Charlotte Department of Transportation

Memorandum

Subject: Rezoning Petition 08-086: Located on both sides of Victoria Avenue north of West 4th Street Extension and east of Johnson and Wales Way

Sheet:
RZ-2

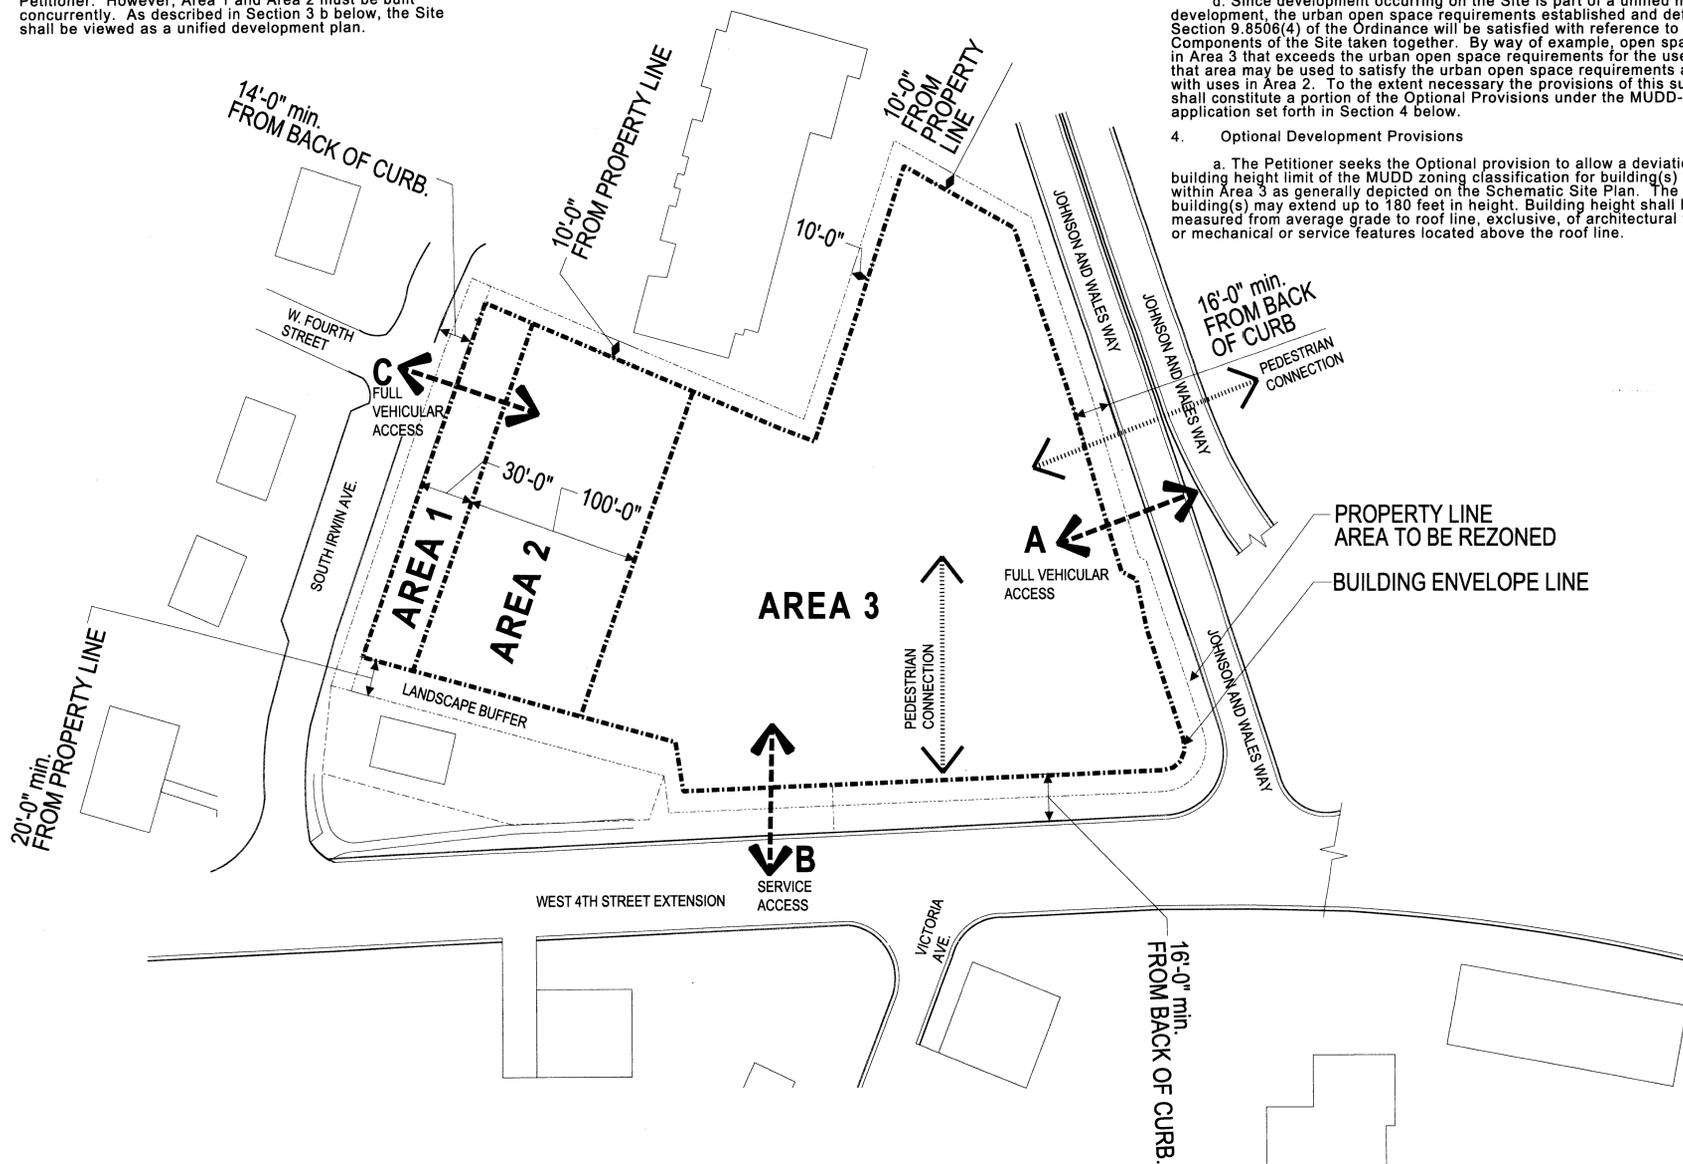
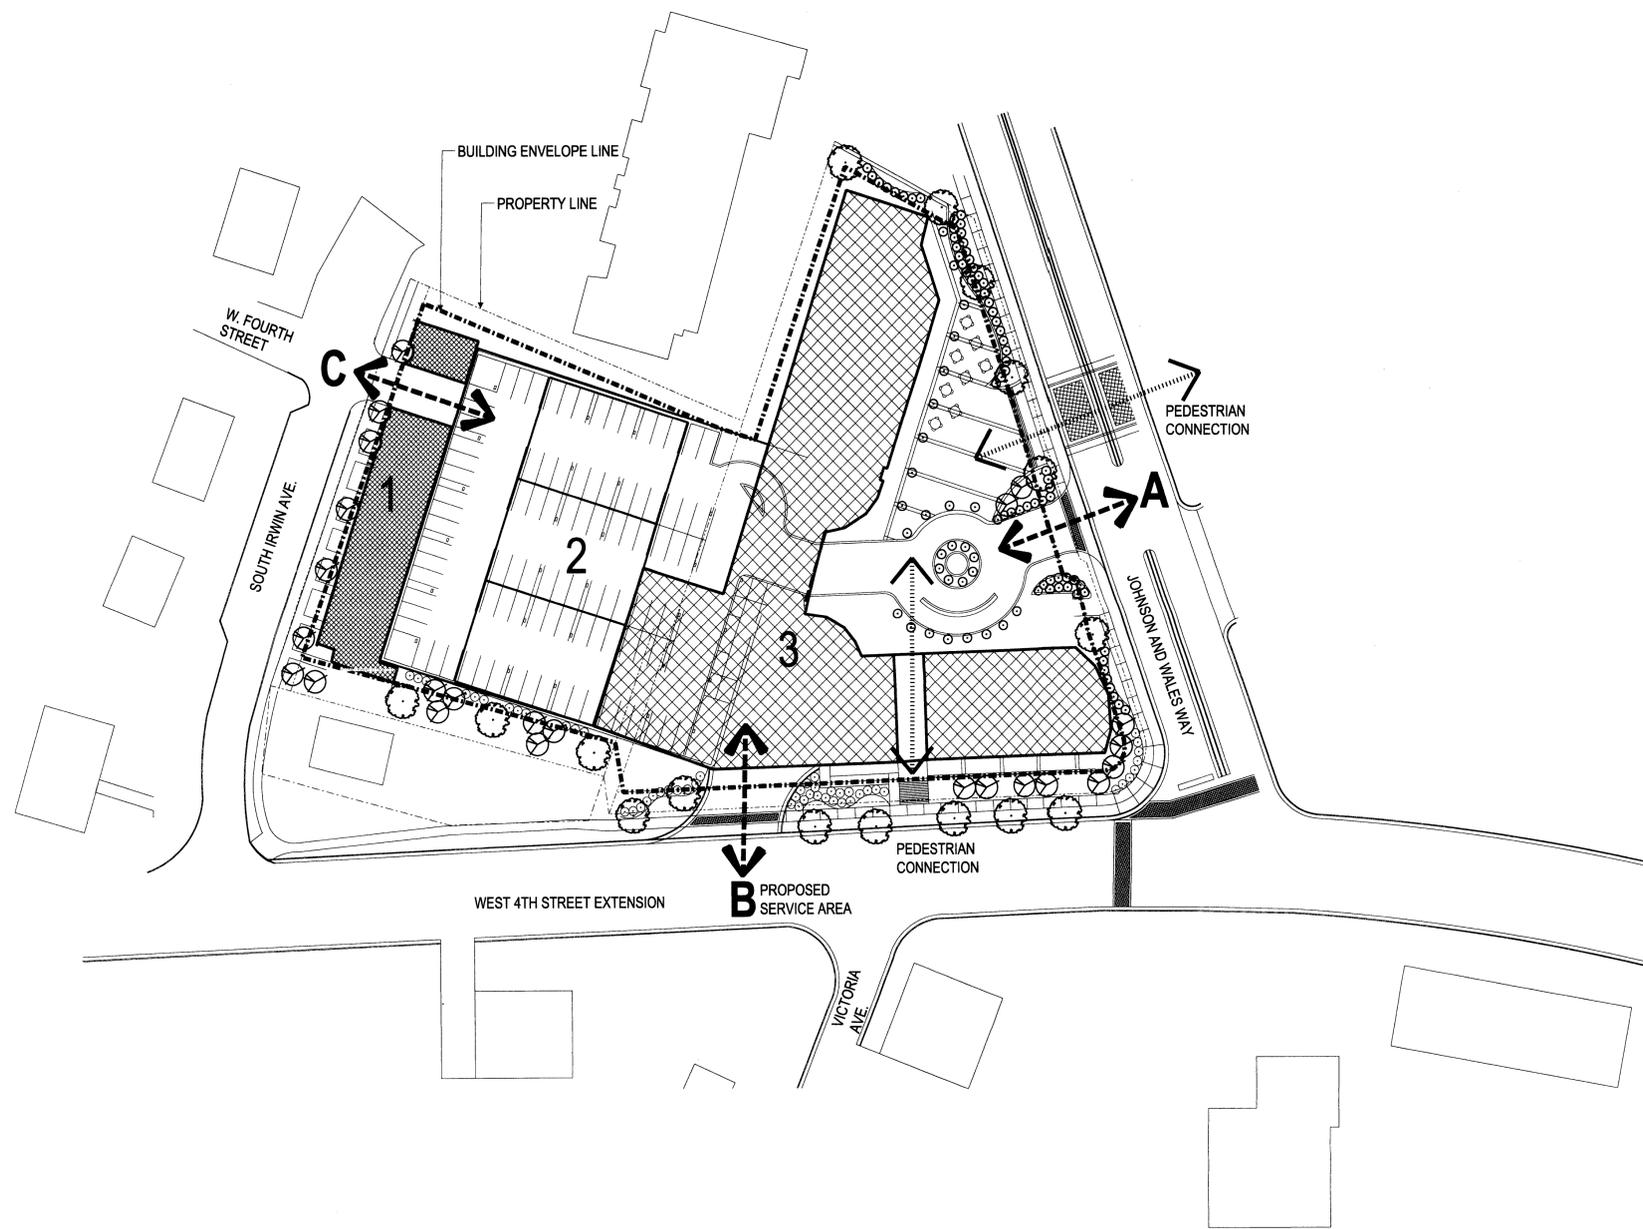
1. We request that a conditional plan be submitted for this site due to the planned redesign of the Johnson and Wales Way/4th Street intersection. This project will create a more urban designed intersection by eliminating the higher speed curve for outbound right-turning movements and by realigning Johnson and Wales Way to intersect 4th Street at 90° to minimize pedestrian crossing distances. The petitioner may contact Jim Kimbler at 704.336.4275 for more information concerning this transportation improvement project.

2. We can support the abandonment of Victoria Avenue through the site in exchange for the dedication of right-of-way that is necessary to accommodate the project described above.
